Our Ref: 2025 / 202 / df

31<sup>st</sup> March 2026

### **Review of Existing Highway Retaining Wall Construction**

SECTION 'G.1 - G.1' THROUGH PROPOSED RETAINING WALL SHOWING REINFORCEMENT
SCALE 1:20

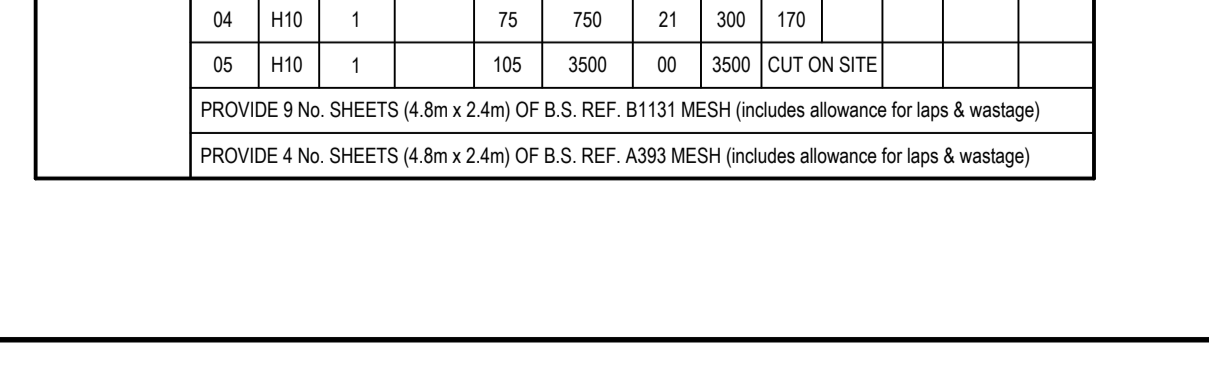
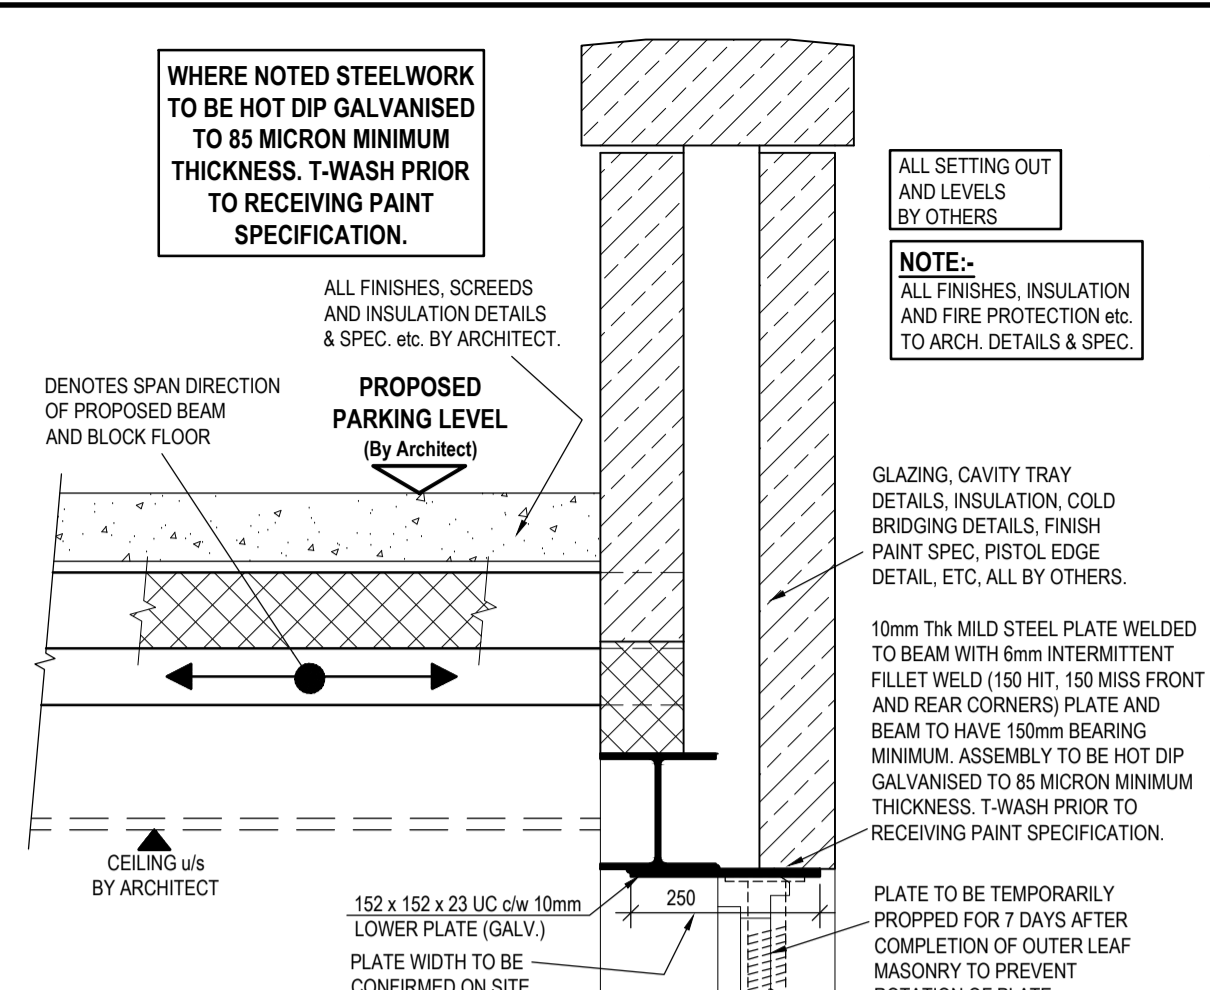
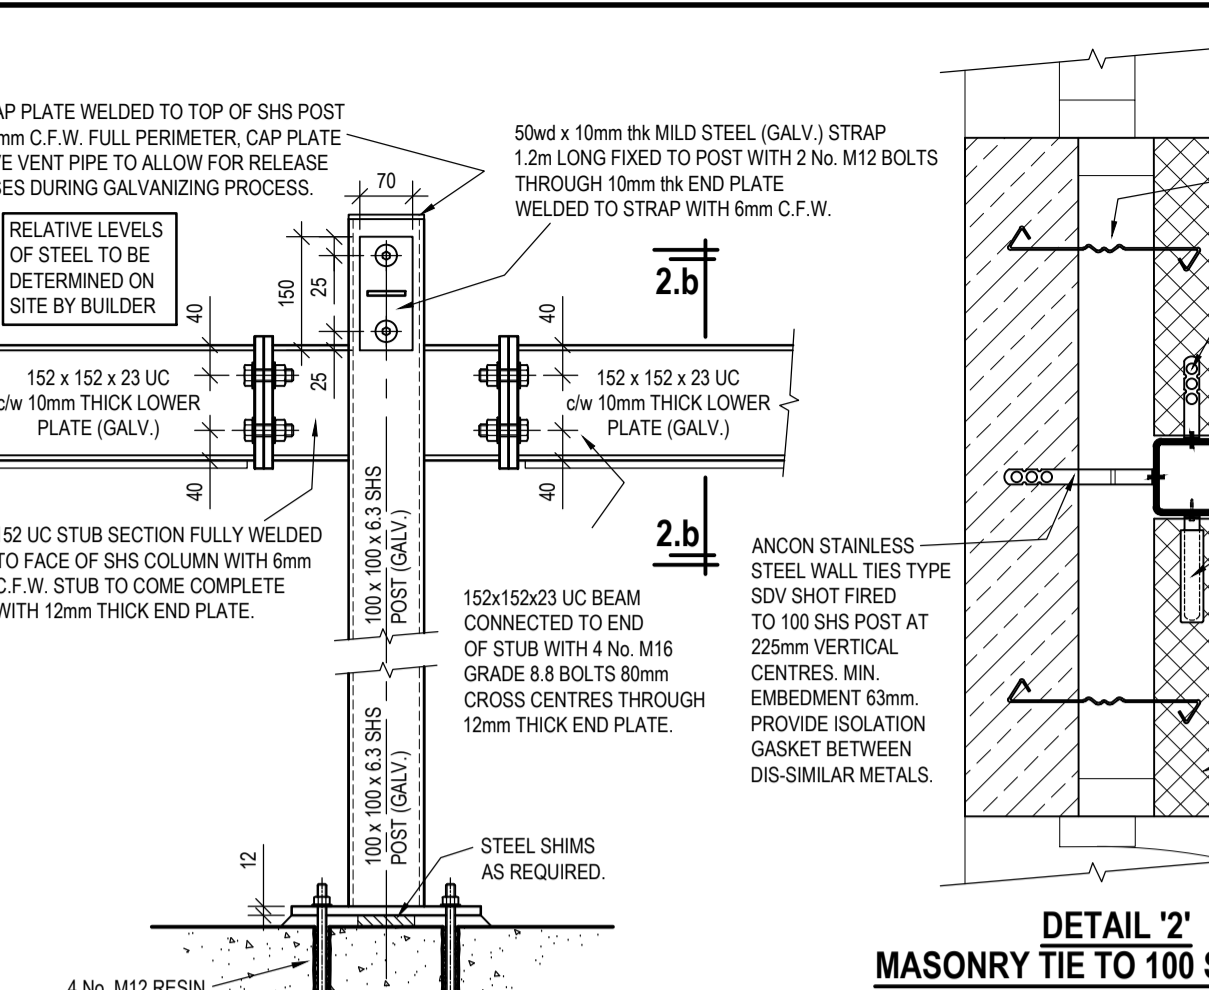
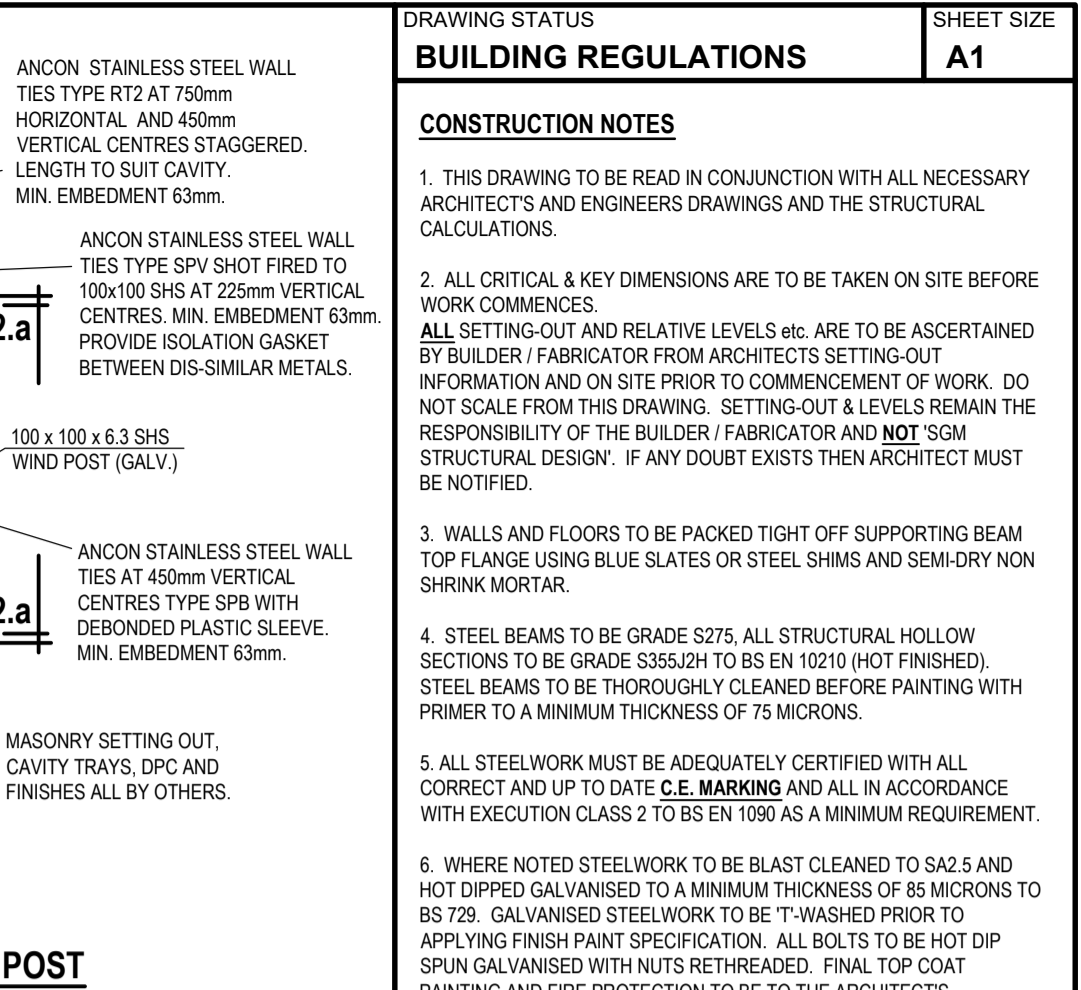
In response to highways comments, with regards to the existing retaining structure, it would be our intention to leave the existing in position, to avoid additional excavation and potential destabilisation of the existing road, in front of the wall we can adopt the detail provided with the terraced subgrade level and compacted hardcore layers in between the rear of the proposed retaining wall and the existing retaining wall.
